Consultation Response from KC, Lead Local Flood Authority
2021/93270 Land at, Station Road, Skelmanthorpe, Huddersfield, HD8 9BA
Discharge of conditions 3 (construction management), 4 (temporary drainage), 5 (temporary waste arrangements), 7 (adoptable roads), 12 (waste storage and collection), 13 (tree protection), 14 (units 23 and 24 revisions), 16 (detailed drainage scheme), 17 (phase II report), 18 (remediation strategy), 23 (materials) and 31 (vegetation removal) of previous permission 2019/91657 for erection of 30 dwellings
Date Responded: 11th January 2023 Responding Officer: Paul Farndale Responding Ref:

Condition 4 – Temporary Drainage

PHASE 1 - SCALE 1:500

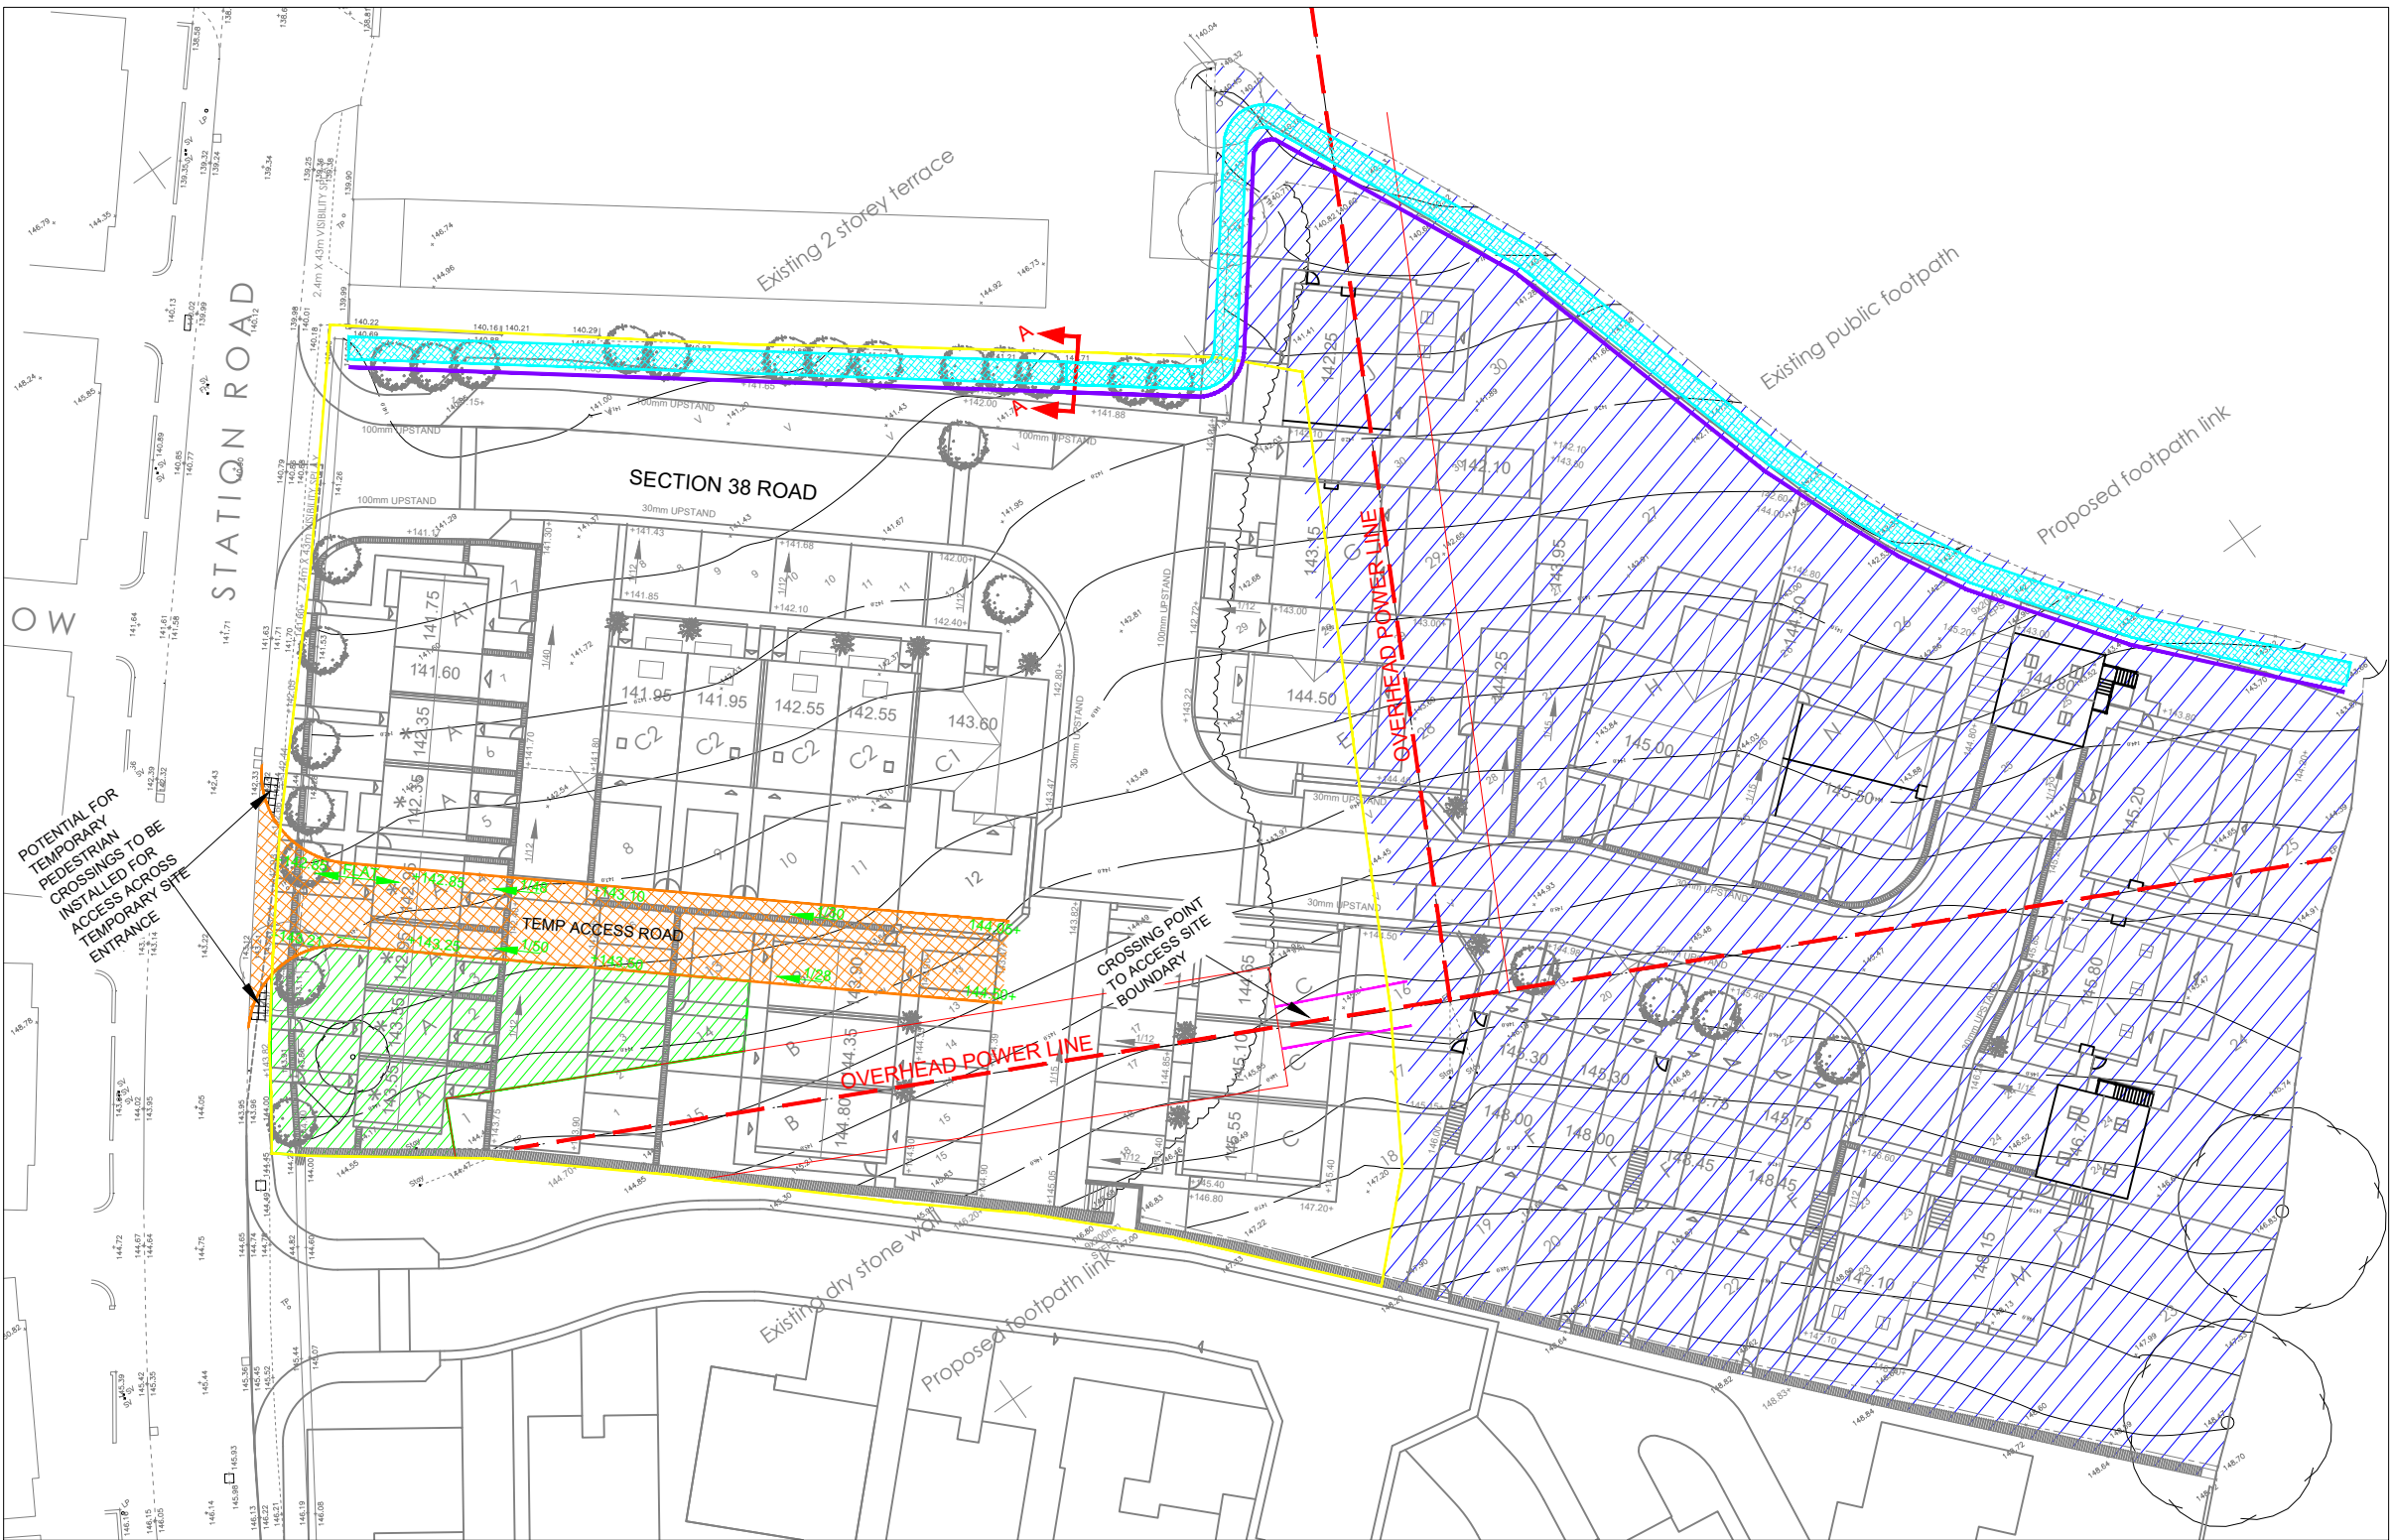
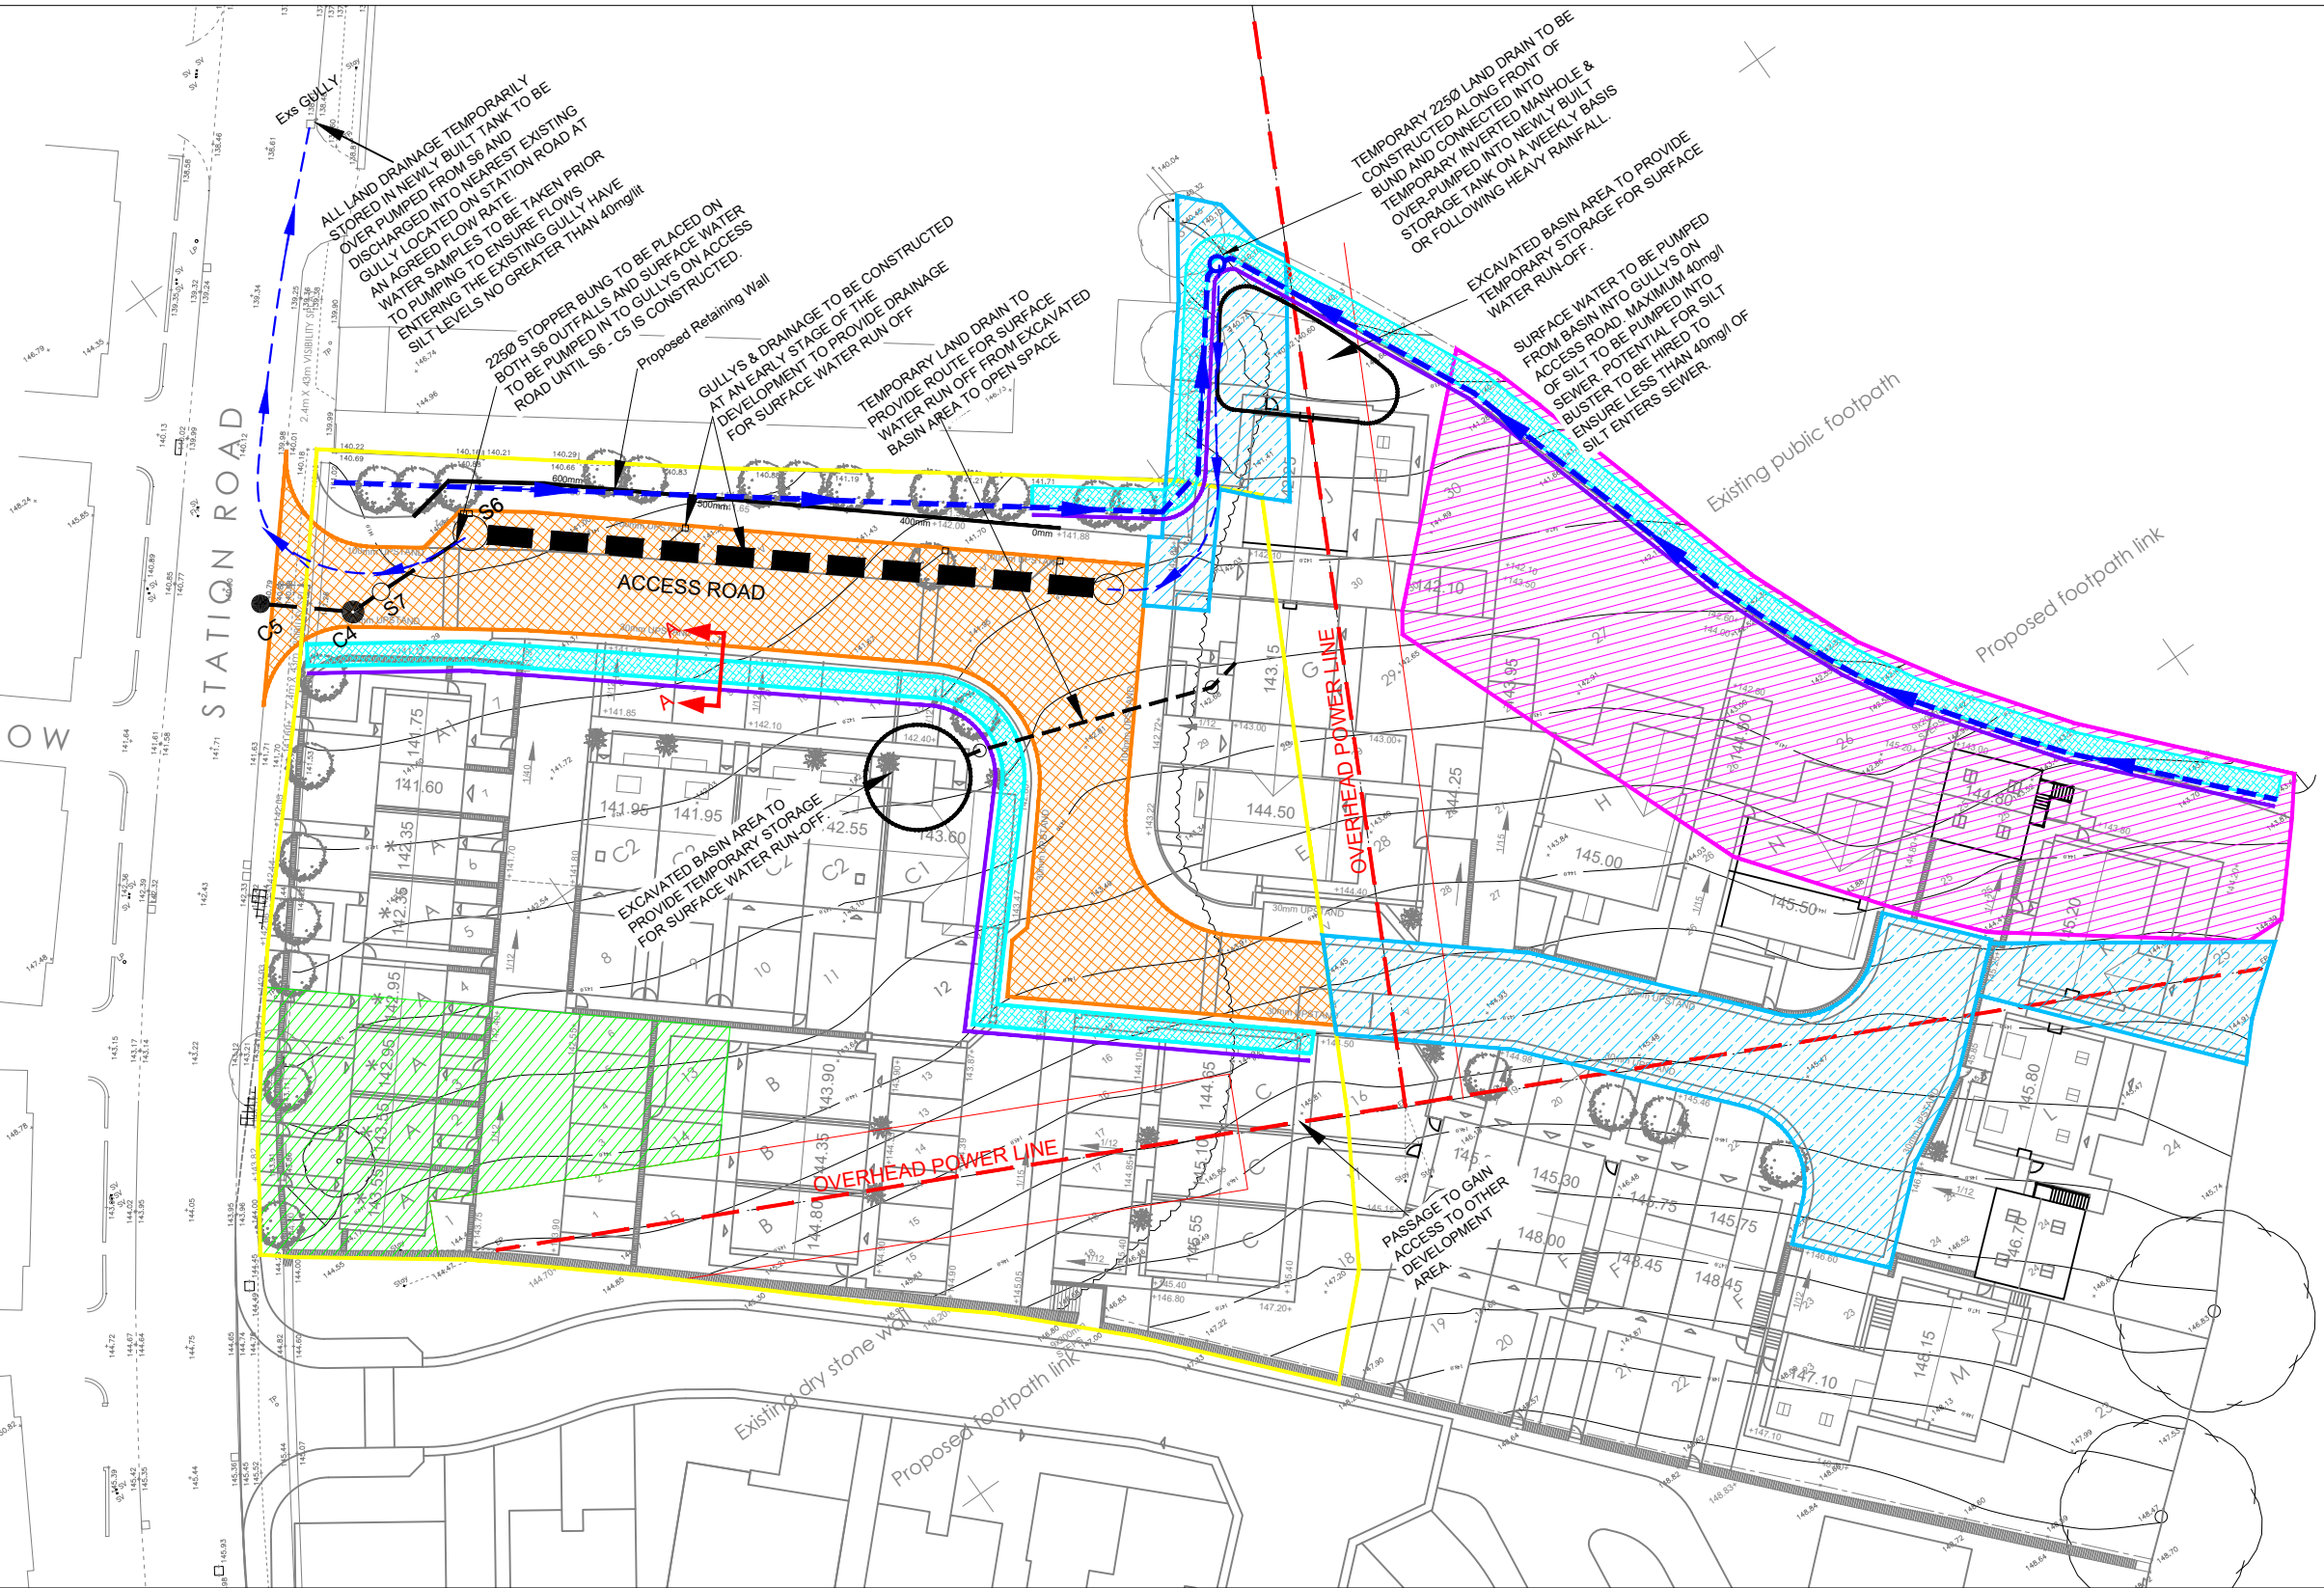
We note and accept the revised construction phase drainage plan utilising the storage tank as a settlement tank prior to over pumping to systems connected to the watercourse, Baildon Dike.

We do advise the developer liaises with the Environment Agency as to whether the methods concerned are labelled as 'treatment' and whether waste licences are required.

Should sediment in surface water leaving the site be a problem we suggest monitoring of samples and the use of flocculation to be considered if necessary.

We are also aware that re-emergence of surface water in neighbouring land is occurring, and several locations have been dye-tested to prove a link from particular areas of the site. The LLFA will continue to work with the developer on this live site to minimise flood and pollution risk.

The accepted plan will need to be monitored and revised where necessary.
